DEVELOPMENT REVIEW BOARD
TRANSPORTATION DEVELOPMENT

DRB Project Number: 2019-002184
Guardian Storage at Osuna

SUBJECT: Site Plan

DATE: January 15, 2020

Plat for Tract G-1-A Academy Place Being Comprised of Tract G-1

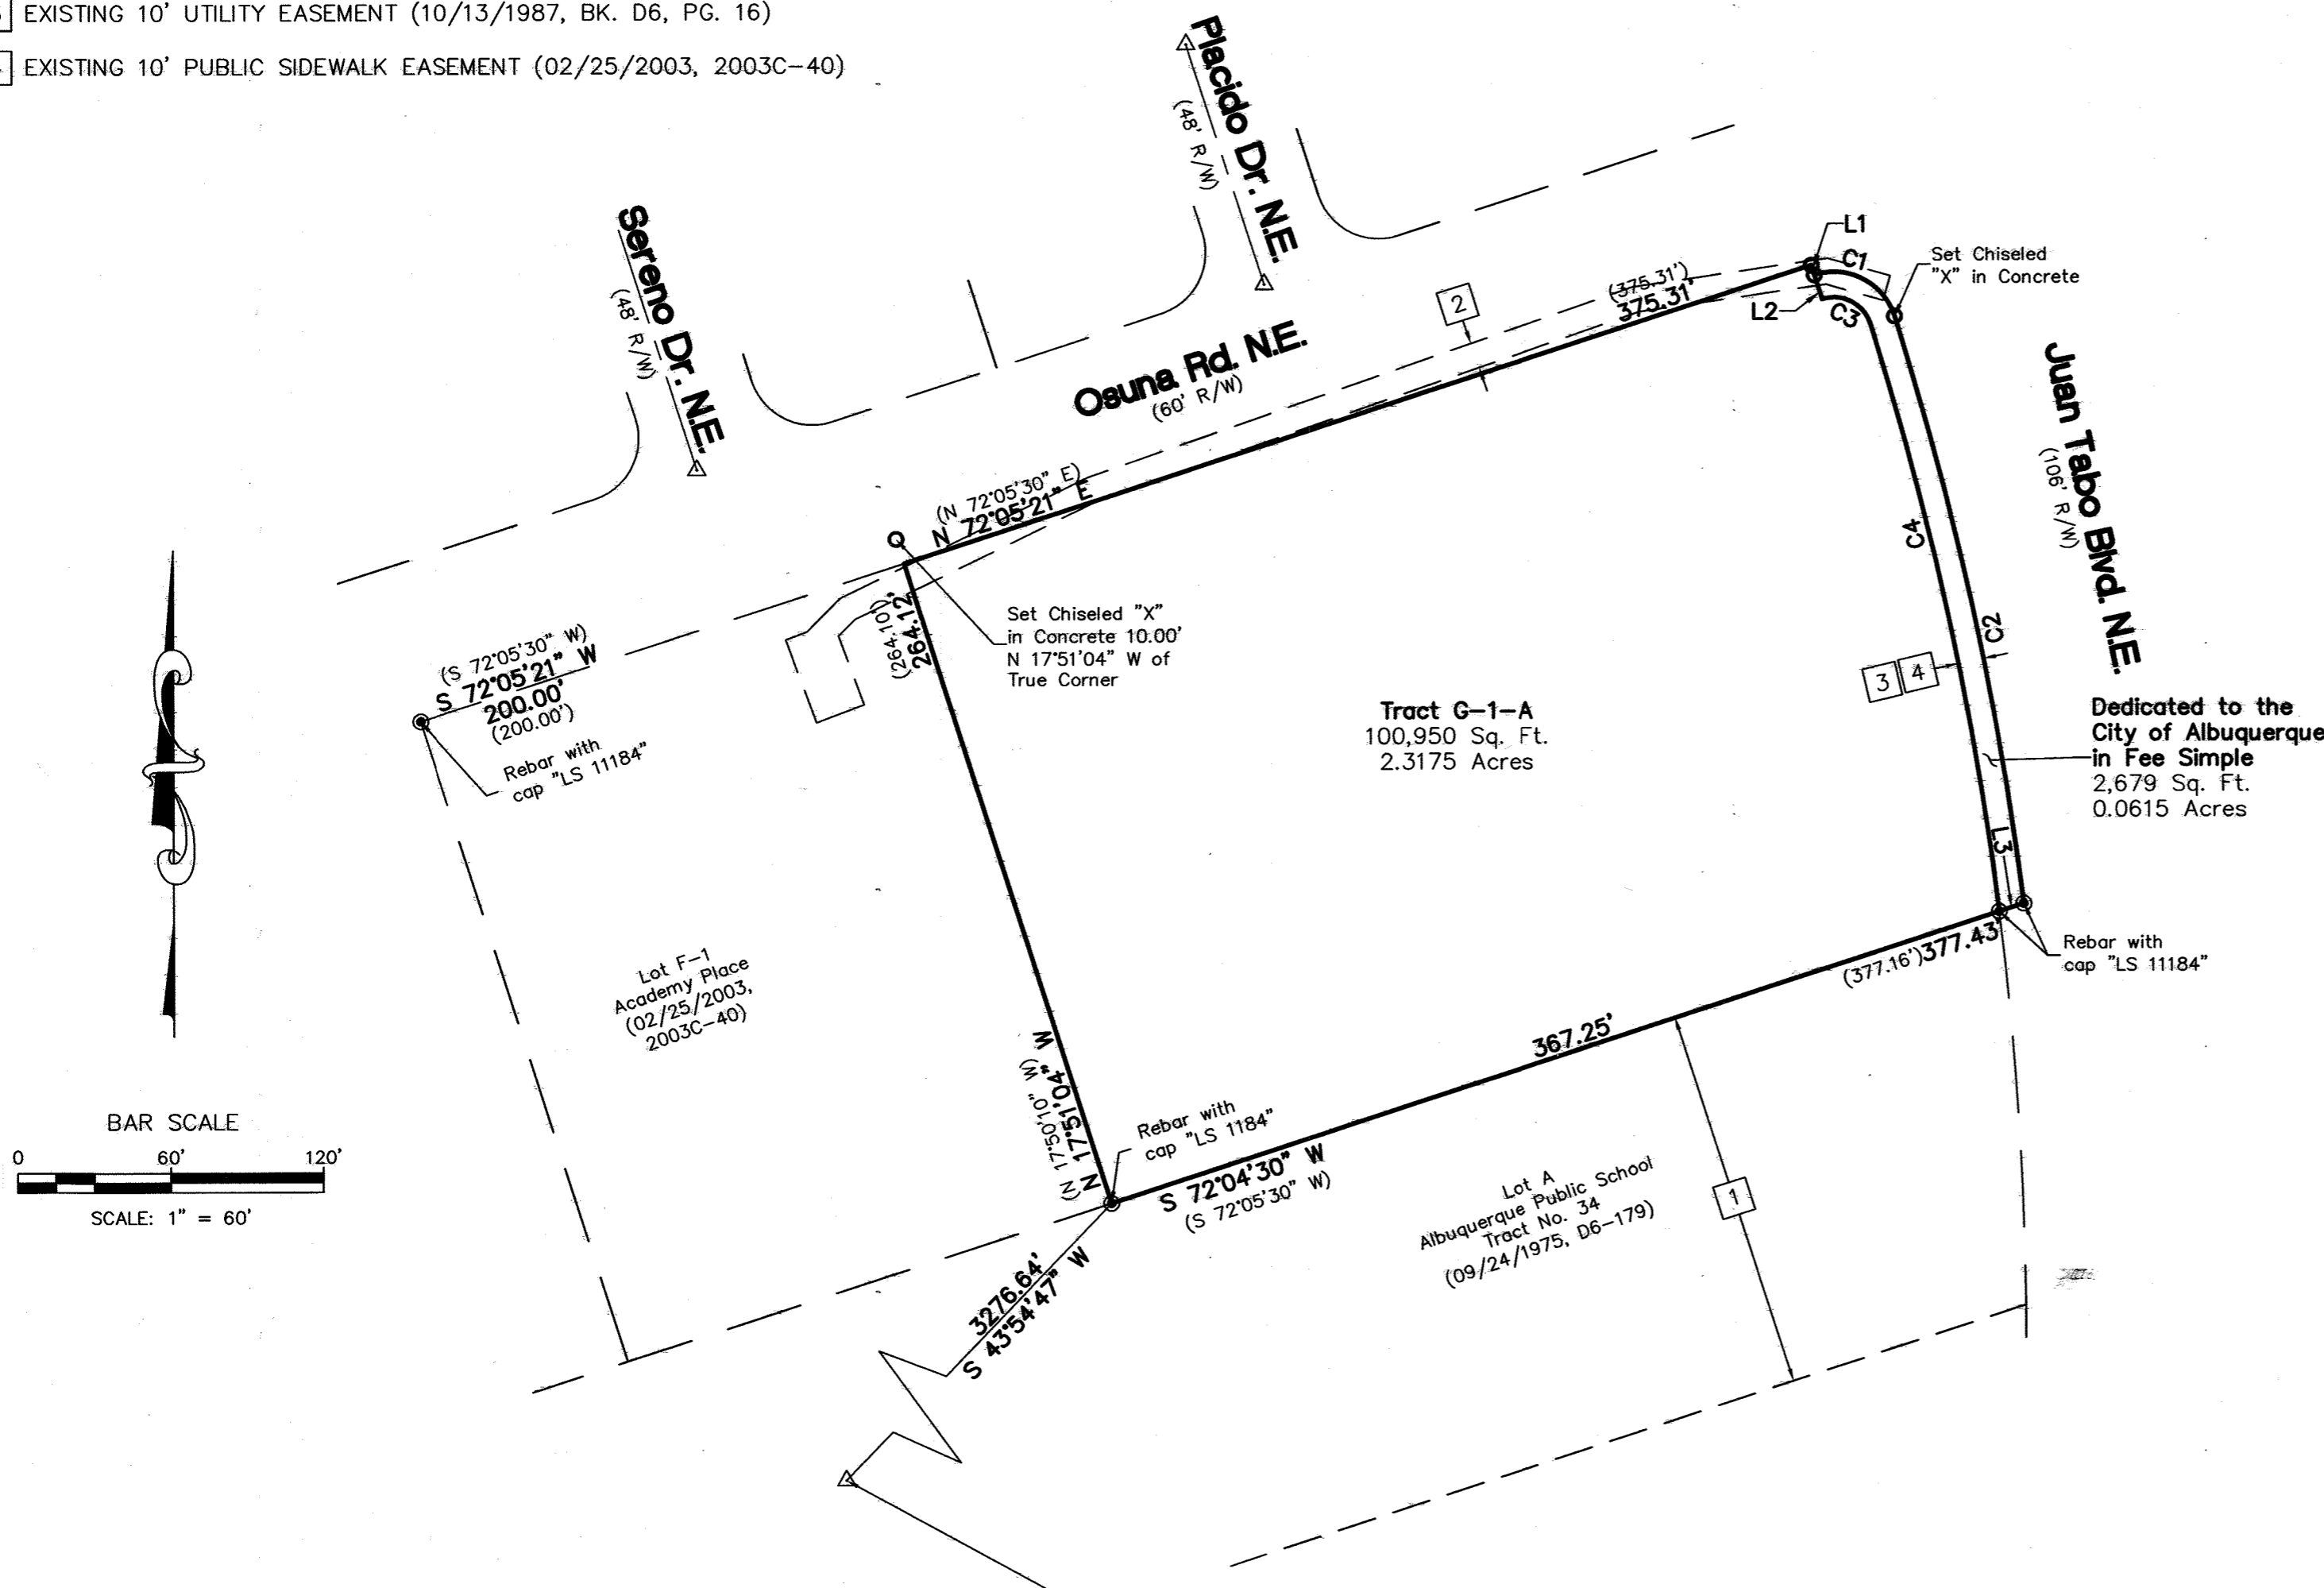
1. Platting action is needed to along Juan Tabo Blvd. to change the 10-foot sidewalk easement to 10-foot of dedicated right-of-way as noted by the supplemental submittal. Therefore, a platting action is required.

5 TYPICAL SIDEWALK
SCALE: NTS

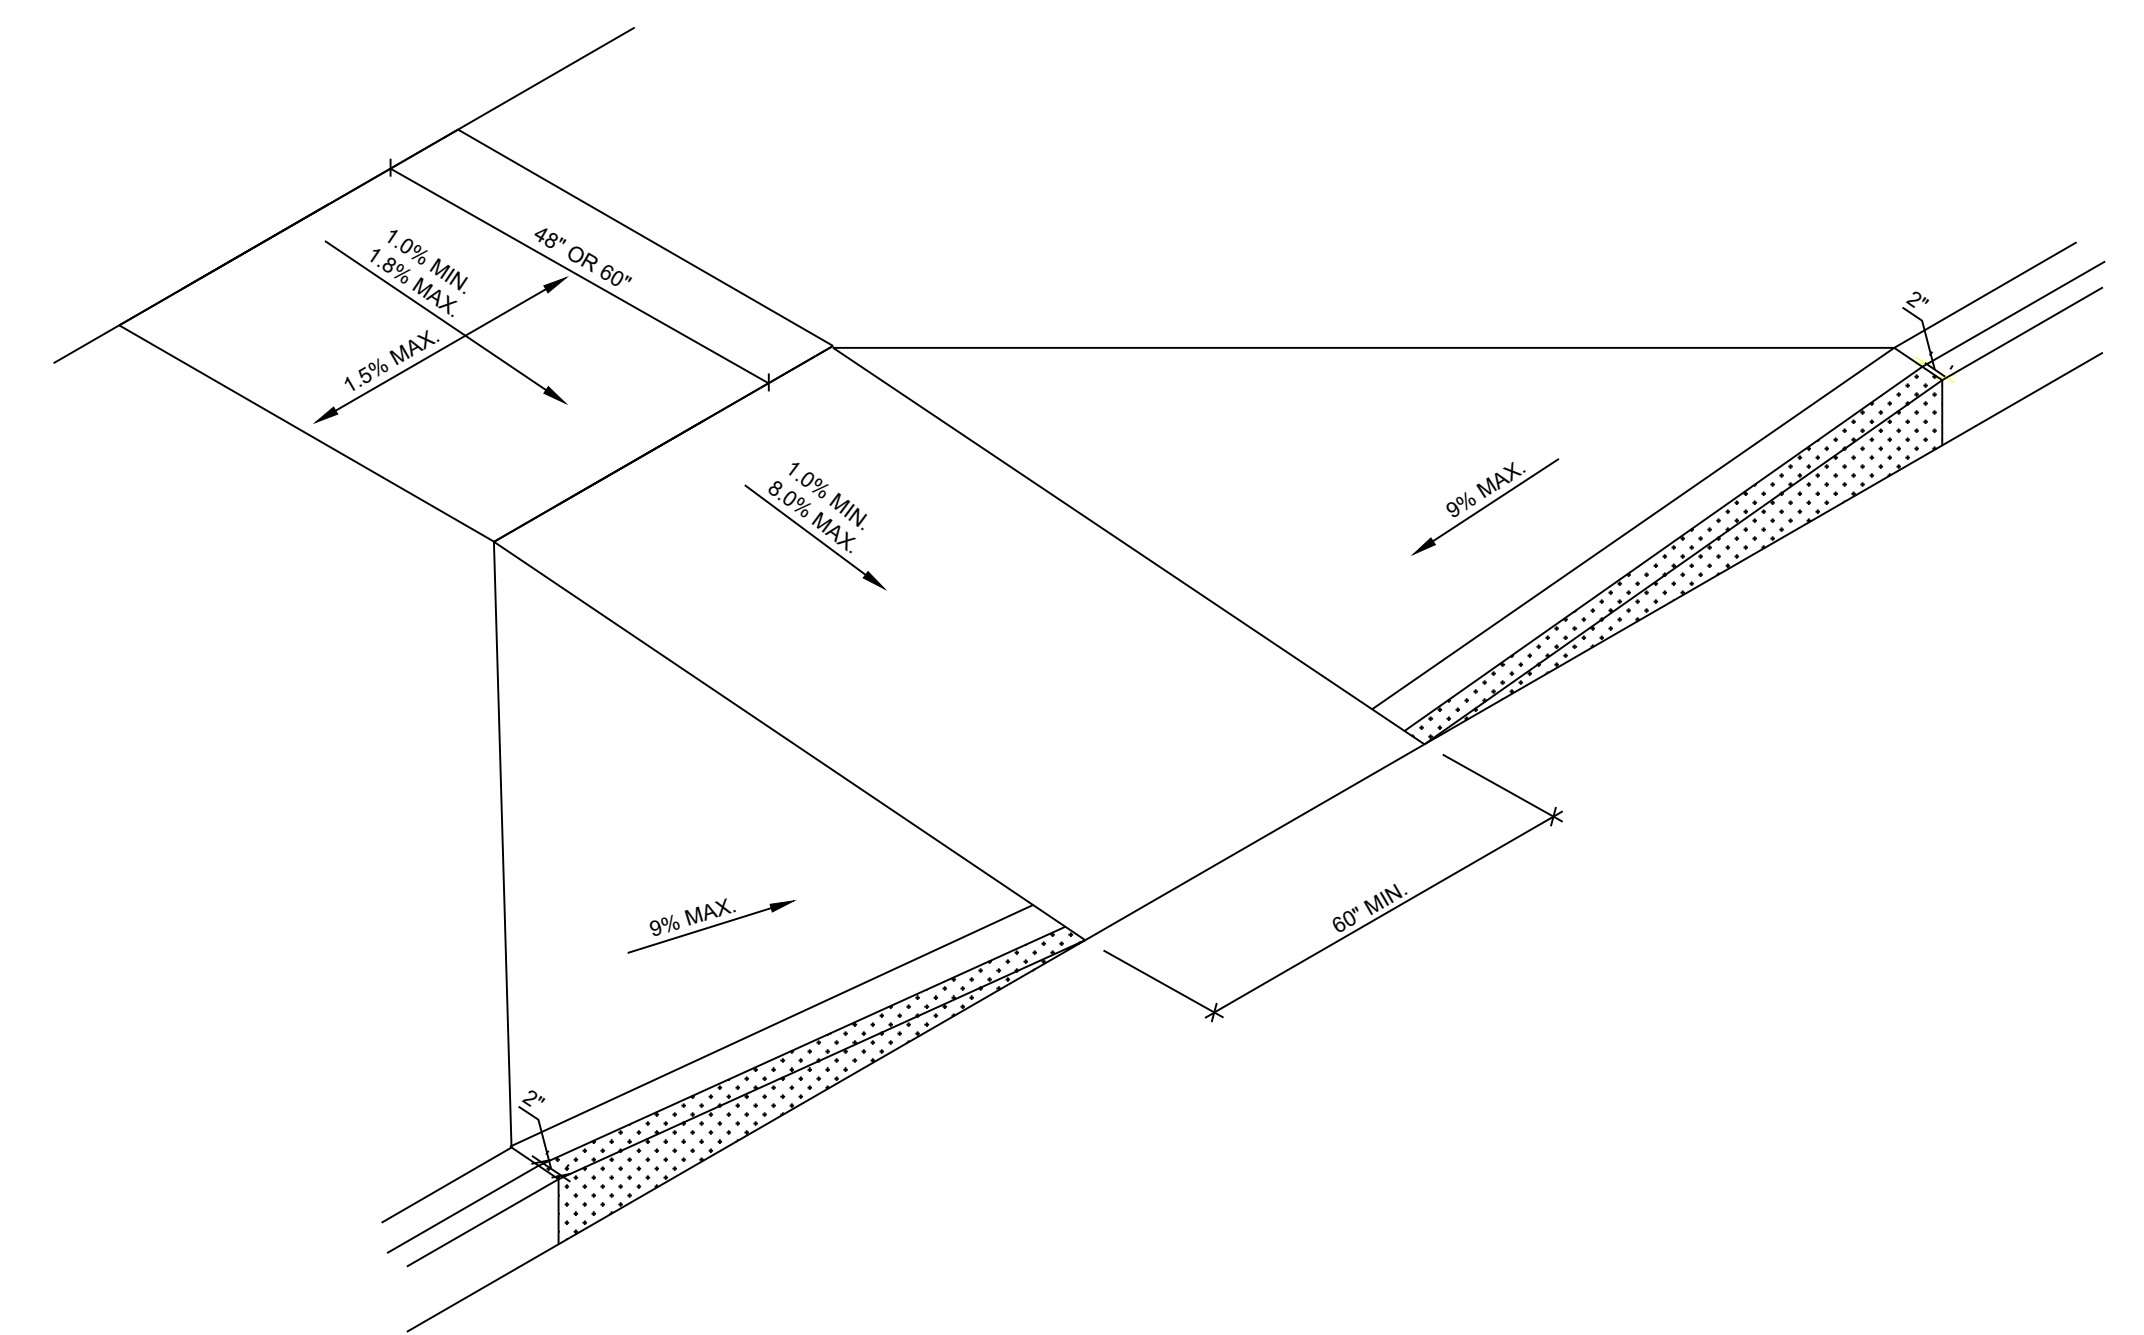
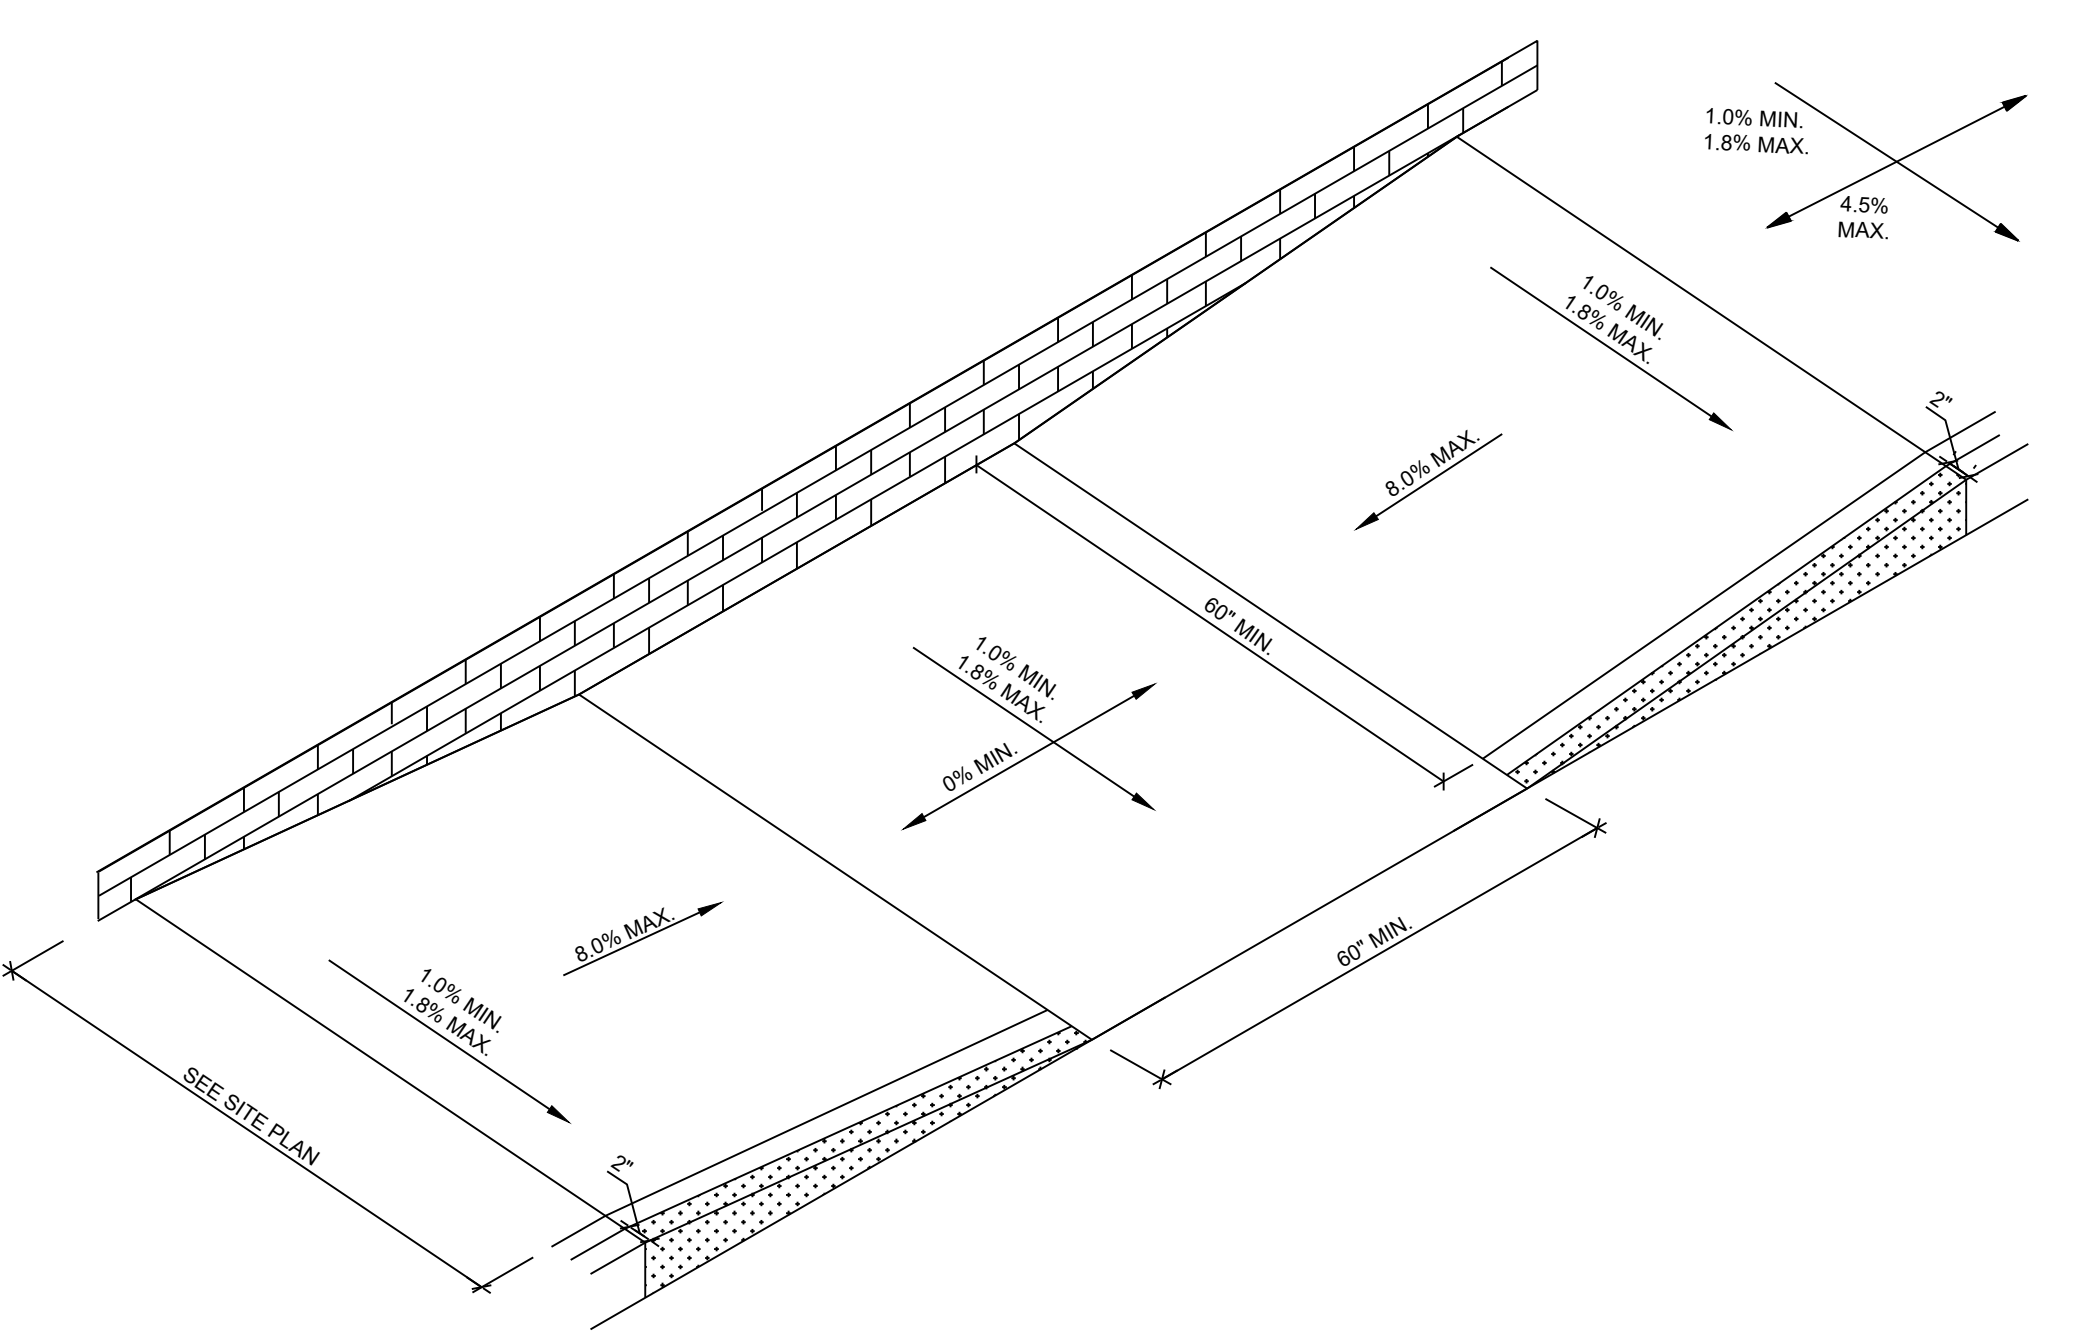
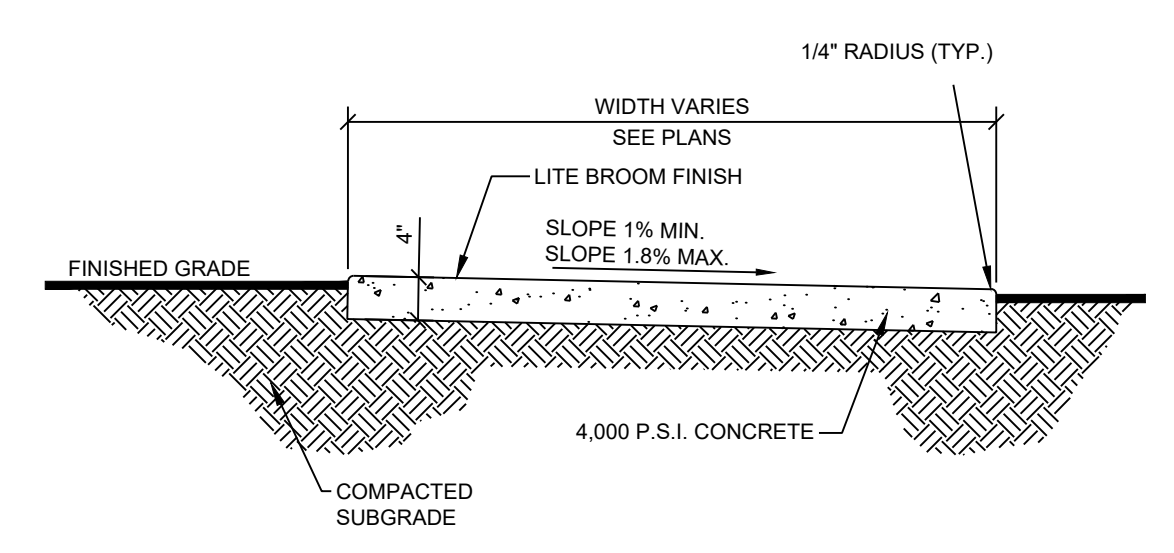
2. Provide curb, curb ramp, and sidewalk details. Sidewalk detail shall show a maximum 2% cross-slope.
3. Dimension parking islands.
4. Provide signage details for the handicapped sign and motorcycle sign. On site plan, show existing and proposed sidewalk widths as well as distance from curb to property line. A minimum 4-foot wide sidewalk is required. The ADA accessible parking sign must have the required language per 66-7-352.4C NMSA 1978 "**Violators Are Subject to a Fine and/or Towing.**" If that language is present it is not visible in the detail.
5. If curb does not separate parking spaces from sidewalk, provide parking bumpers.
6. Provide cross-section for new sidewalk along Osuna Road NE.
7. Receive approval from Fire Marshall.
